**DISAPPROVED**  
**Plan Review**  
 03/17/2023 2:11:55 PM  
 dsdarchuleta  
 EPC Planning & Community  
 Development Department

40± Ac

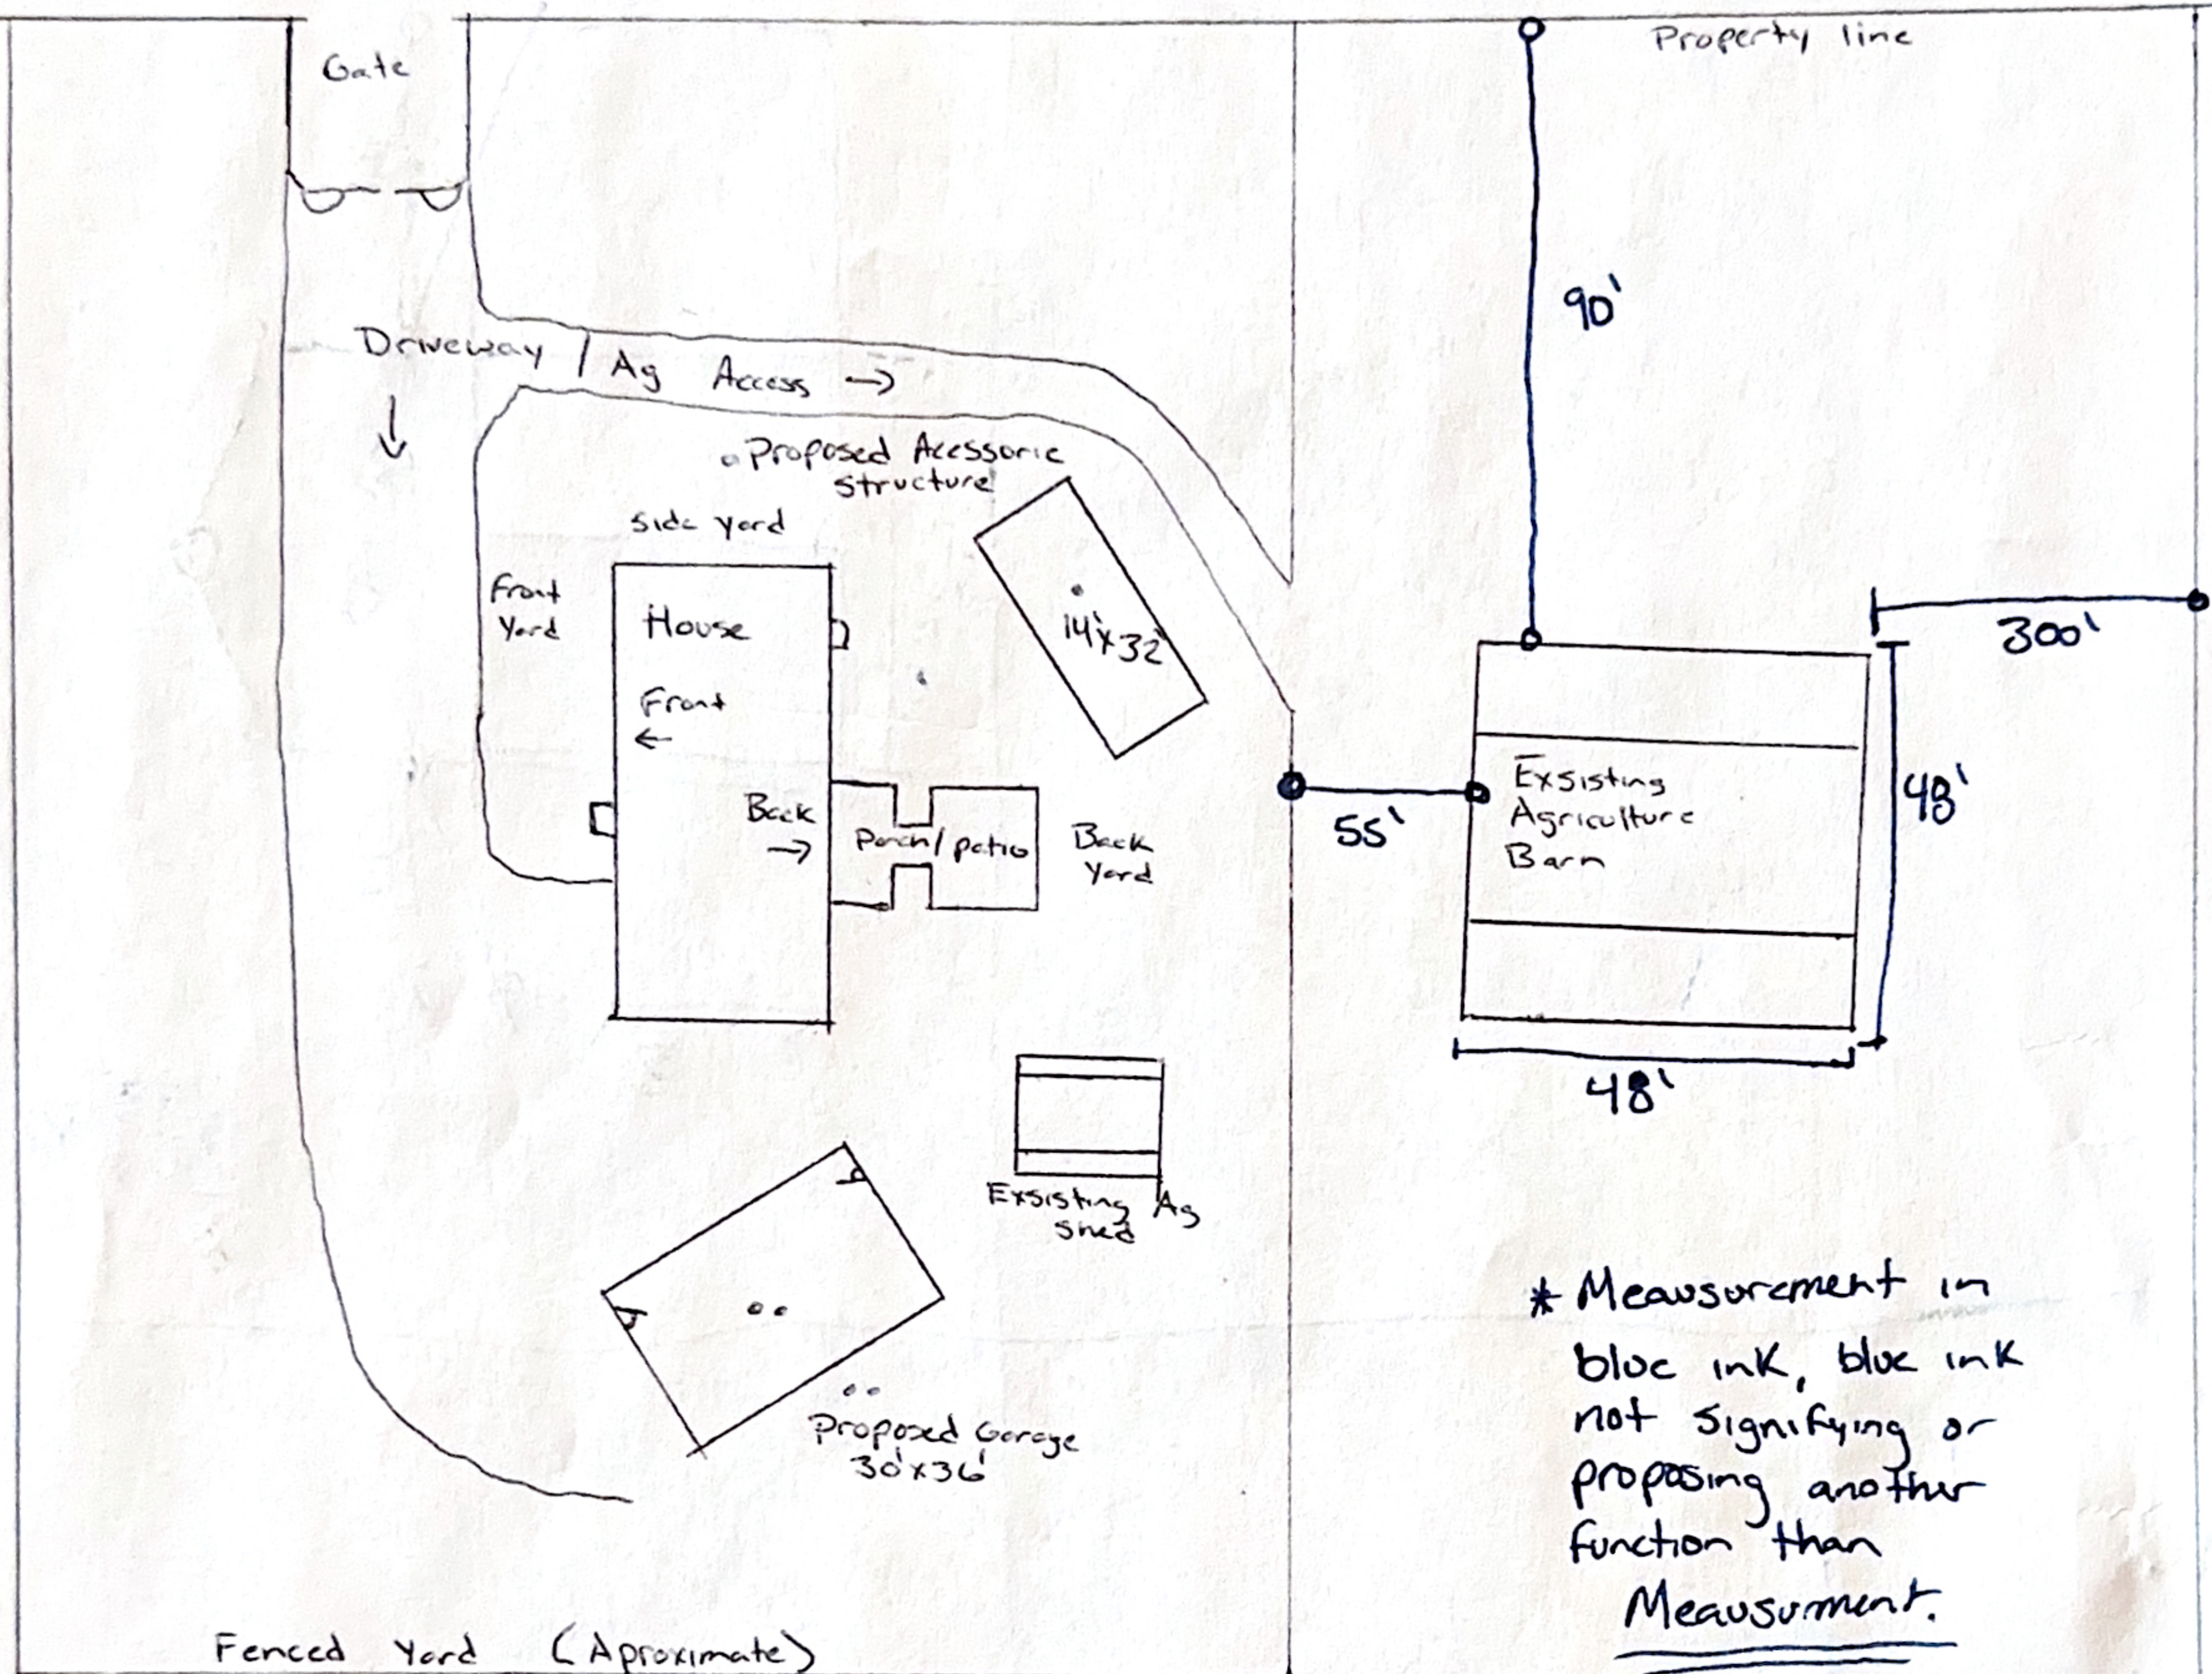
- (1) SHOW ONLY ALL EXISTING STRUCTURES AND THE STRUCTURE TO BE REVIEWED
- (2) SITE PLAN TO HAVE PARCEL ADDRESS
